DECISION DELEGATED TO DEVELOPMENT MANAGER

Application No: H09-0529-20 **Applicant:** NKW Design Ltd.
Proposal: Erection of 6 Self-build Eco Homes with access from Fen Road
Location: Land Adjacent 65 Fen Road Holbeach Spalding
Terminal Date: 2nd October 2020

Site Layout Plan: 1285-004

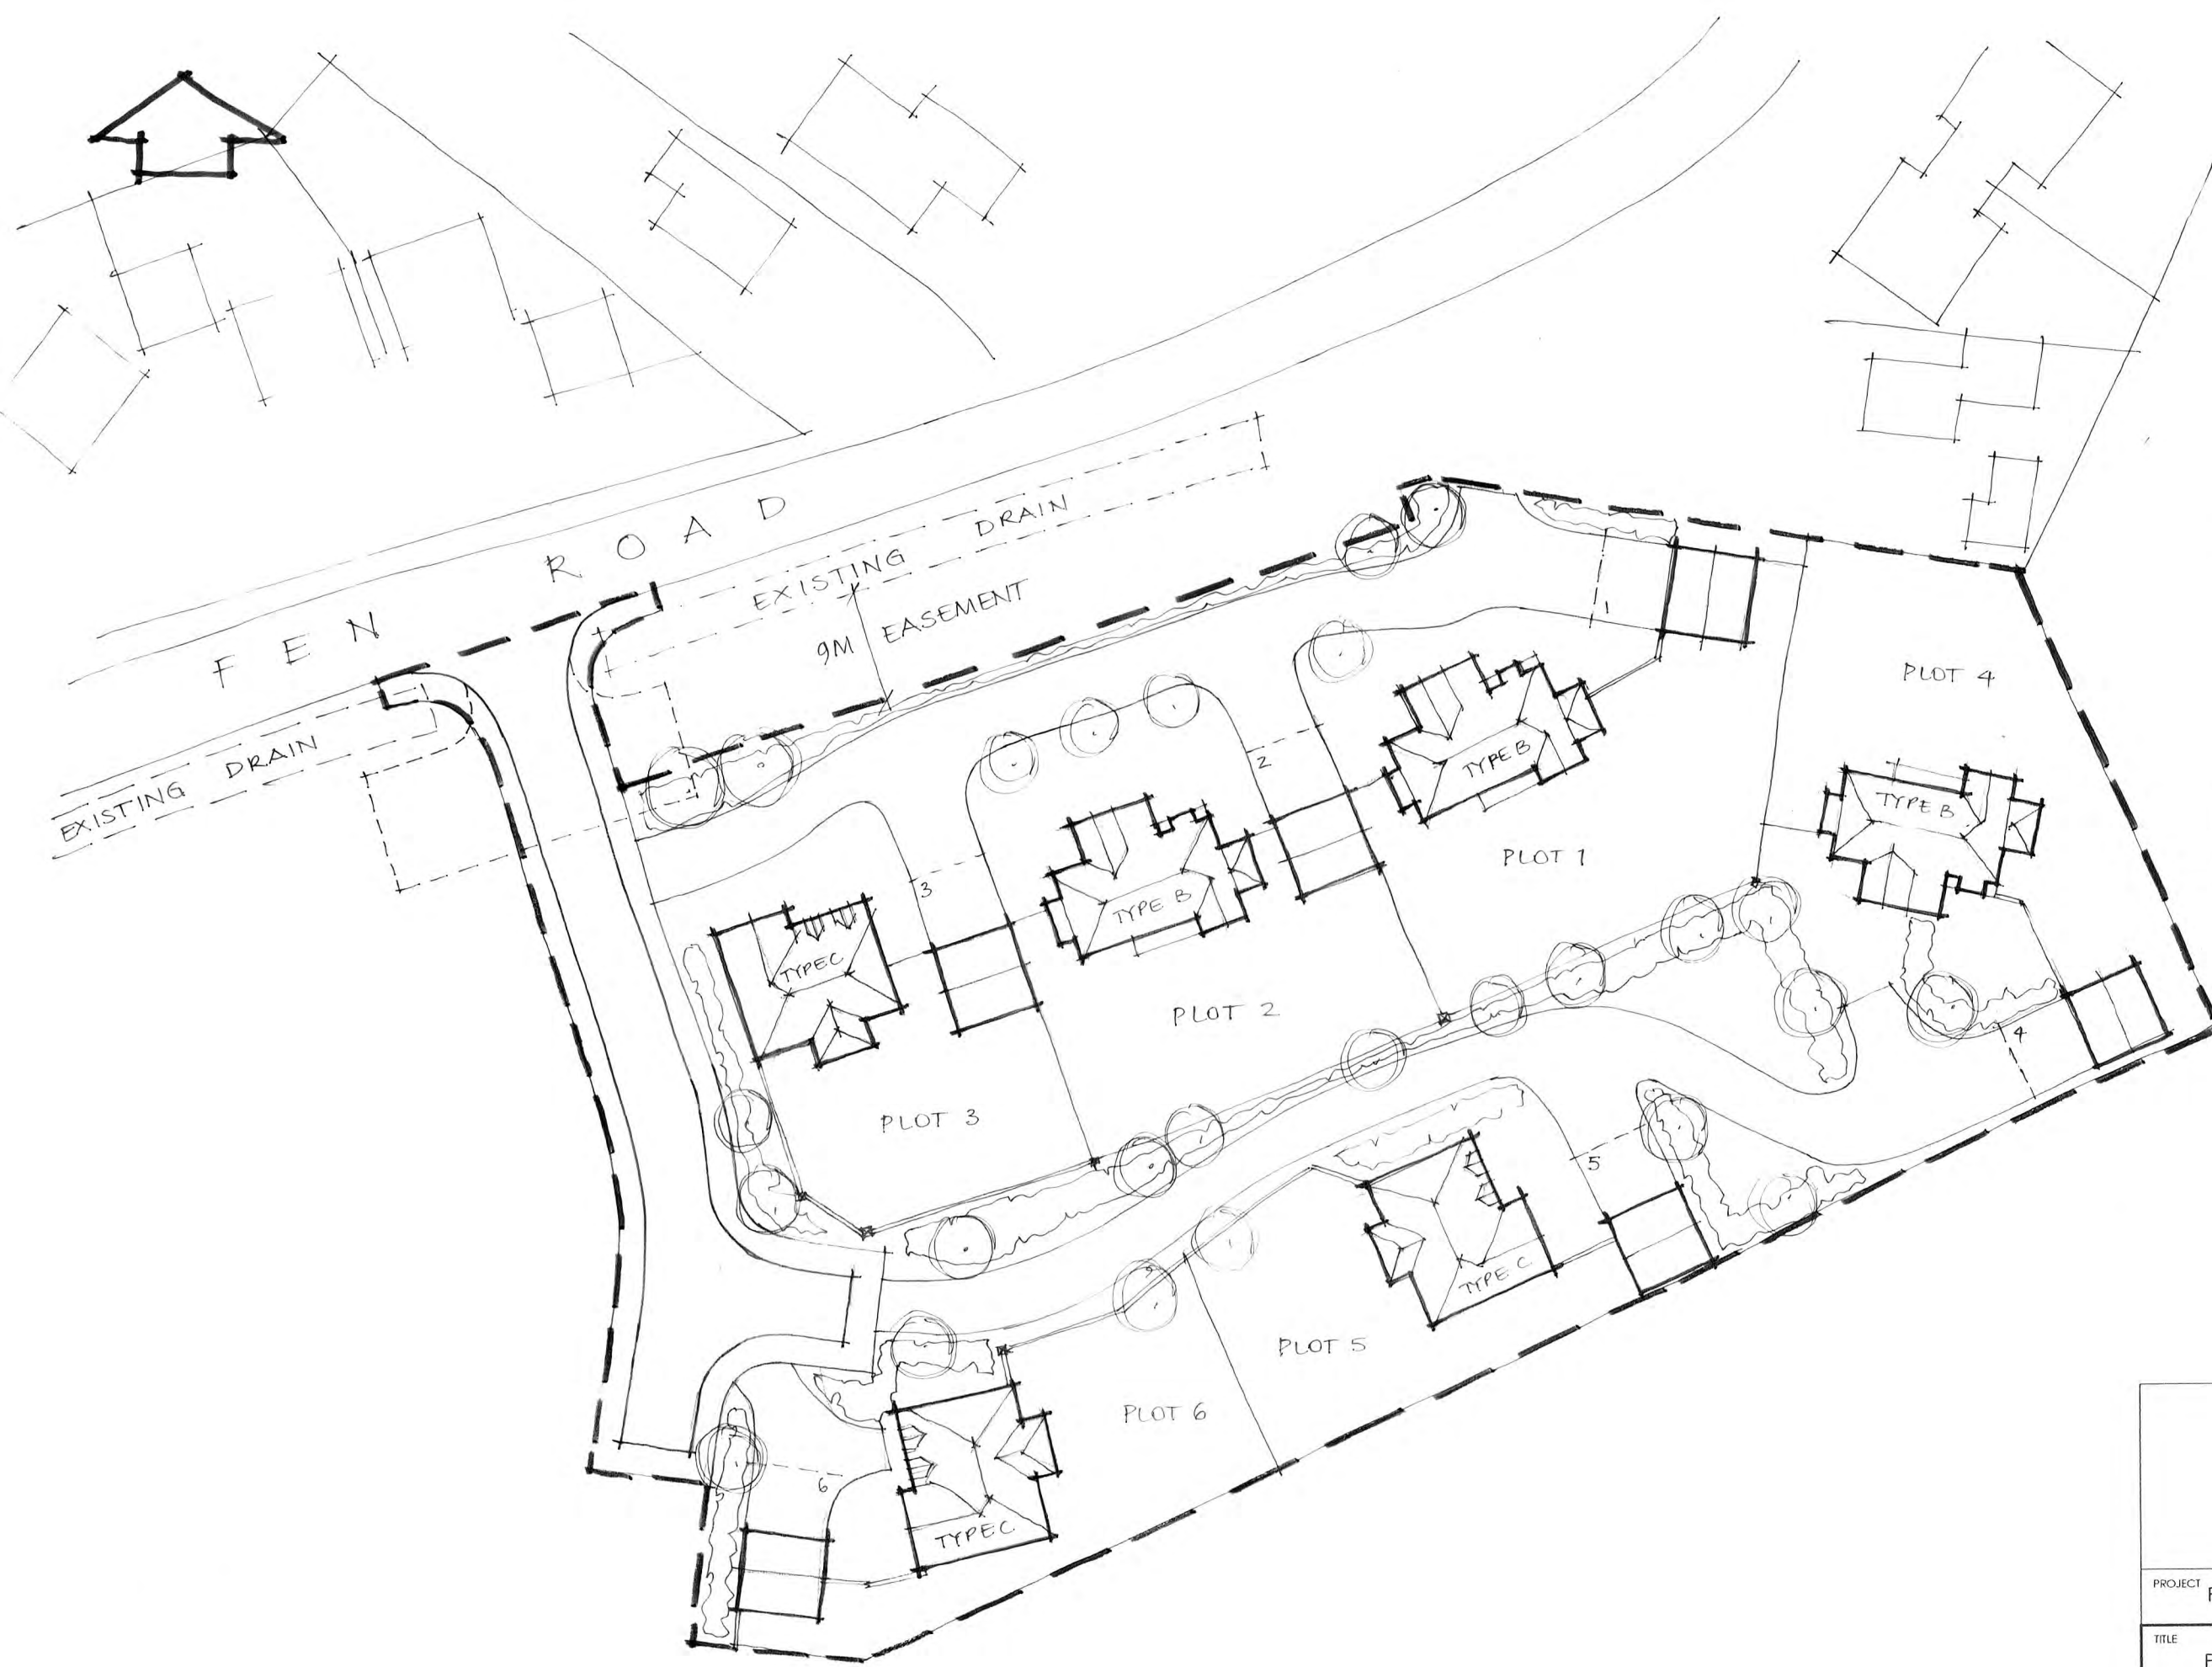
The illustrative layout plan shows a dwelling on plot 4 with its rear elevation facing no 65 Fen Road. However, the boundary is currently de-lineated by a high Leylandii hedge. Moreover, there is sufficient separation distance in any case, including dwellings opposite. It is considered that neighbouring residents would not be materially harmed in terms of overlooking, lack of privacy, overshadowing, overbearing effect, noise and disturbance, etc. Although there would be some impact during the construction stage it would be temporary.
